OBJECTION TO 2021/62/42116/E TO

RE 23 FALL LANE WEISAP/MR A BLAKEY

PROPOSED ERECTION OF DETACHED DWELLING.
AND RE SITE OF GARAGE.

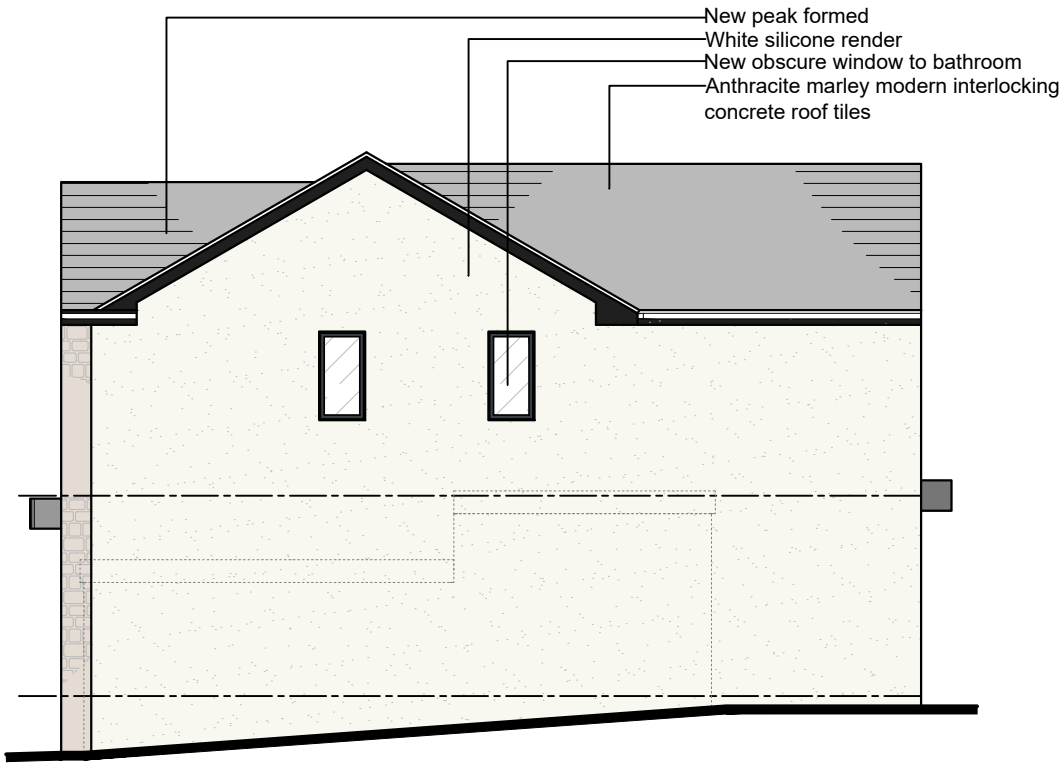
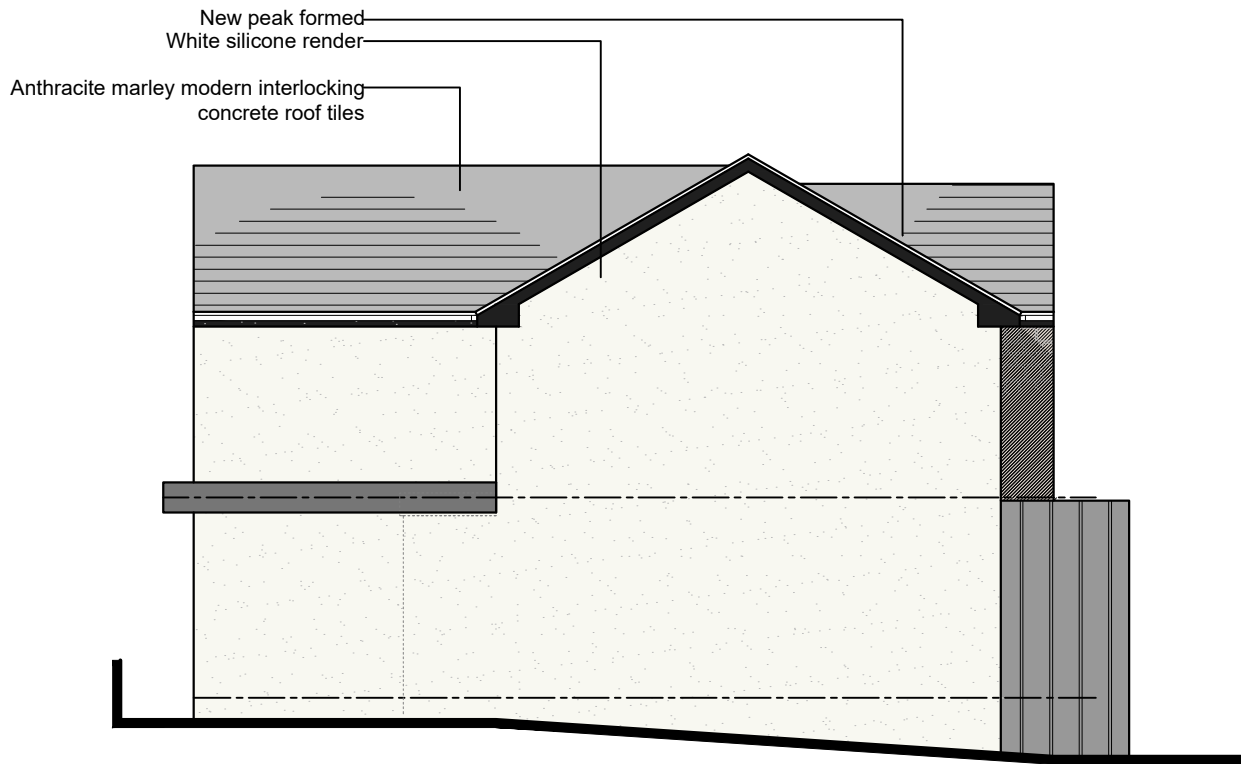
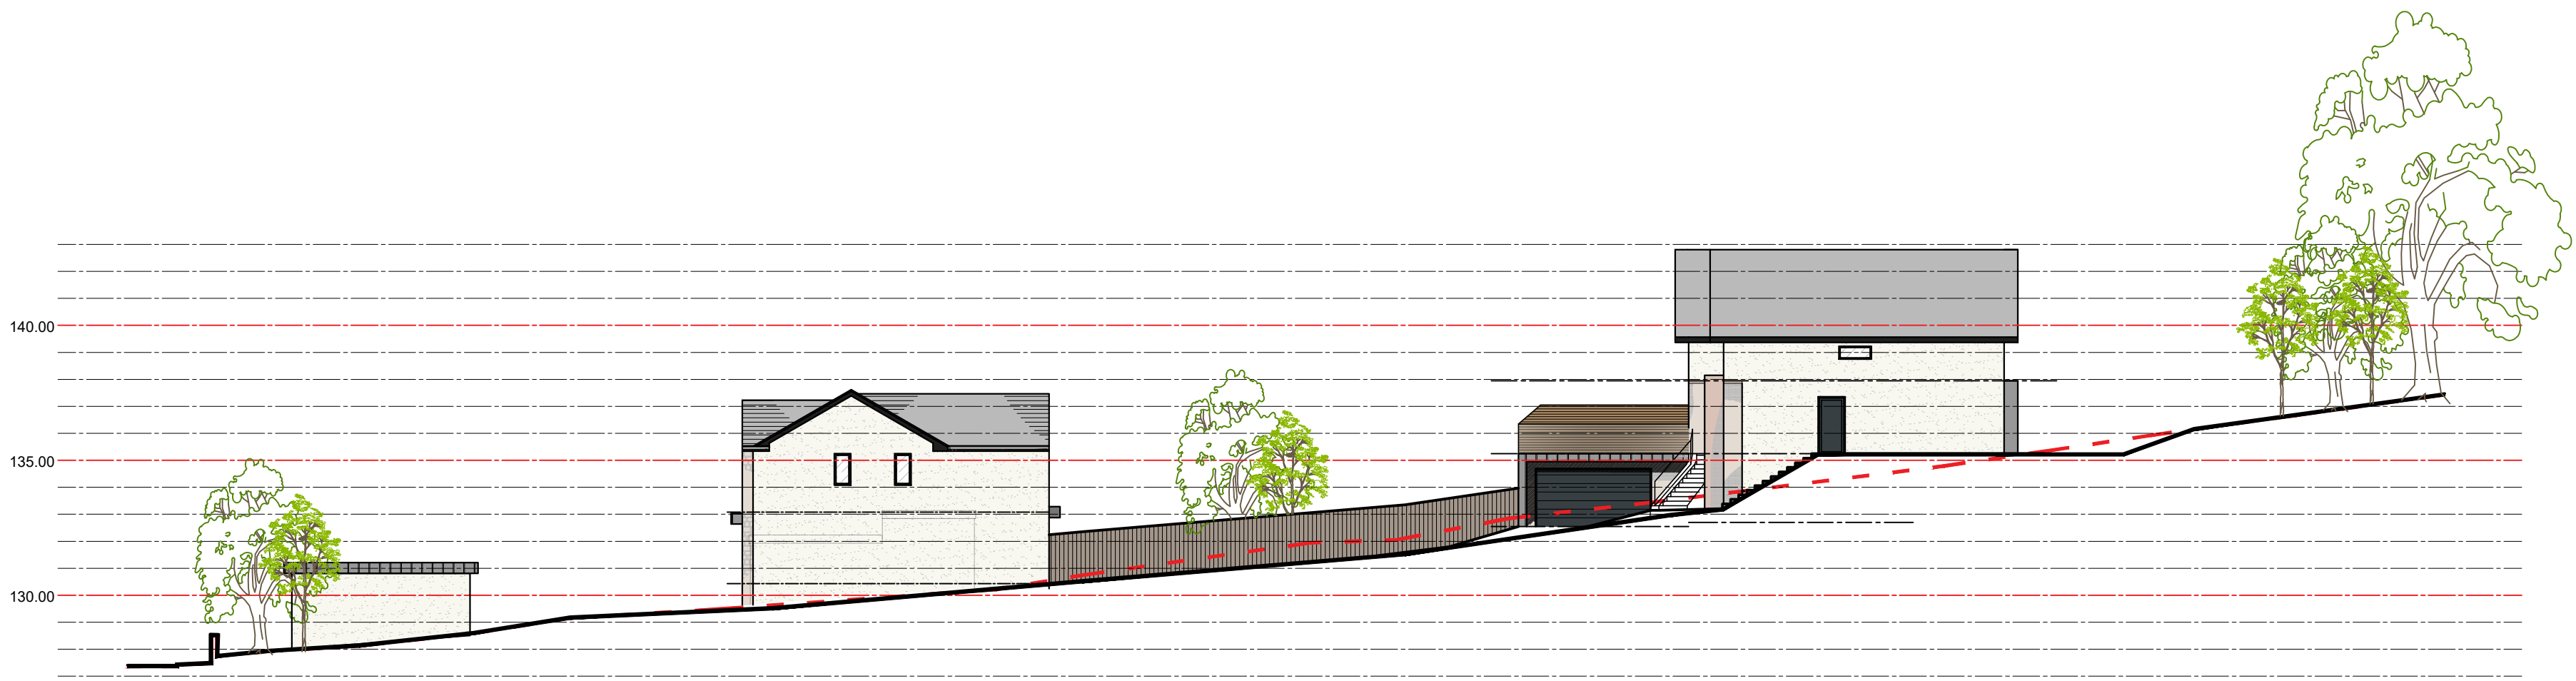
THE PROPOSED DWELLING IS DISPROPORTIONATE
IN HEIGHT AND SIZE TO THE SURROUNDING
DETACHED HOUSES. AND OVERLOOKS
BEDROOM WINDOWS WE WILL BE LOSING.
A LOT OF PRIVACY
MATURE TREES 50 YEARS OLD HAVE BEEN FELLED
THE BUNGALOW THAT WAS BUILT BEHIND
MY PROPERTY WAS BUILT IN A GARDEN
TWICE THE SIZE OF NUMBER 23, AND
I WAS INFORMED THAT THE WHOLE
PIECE OF LAND BEHIND 21, 25, 27,
WAS ~~ONE~~ LAND THAT HAS A
COVENANT ON IT STATING 1 DWELLING
PLUS OUTHOUSE ON EACH PLOT!
ITS NOT JUST THE BACK GARDEN
THAT IS PROPOSED FOR DEVELOPMENT
THE FRONT IS, LARGE DOUBLE GARAGE
AND LARGE CAR PARK.
IN SUMMARY THIS IS OVER DEVELOPMENT!
I WOULD REQUEST A VISIT FROM
YOURSELF IF THAT IS POSSIBLY
I ENCLOSE A S.A.E FOR REPLY
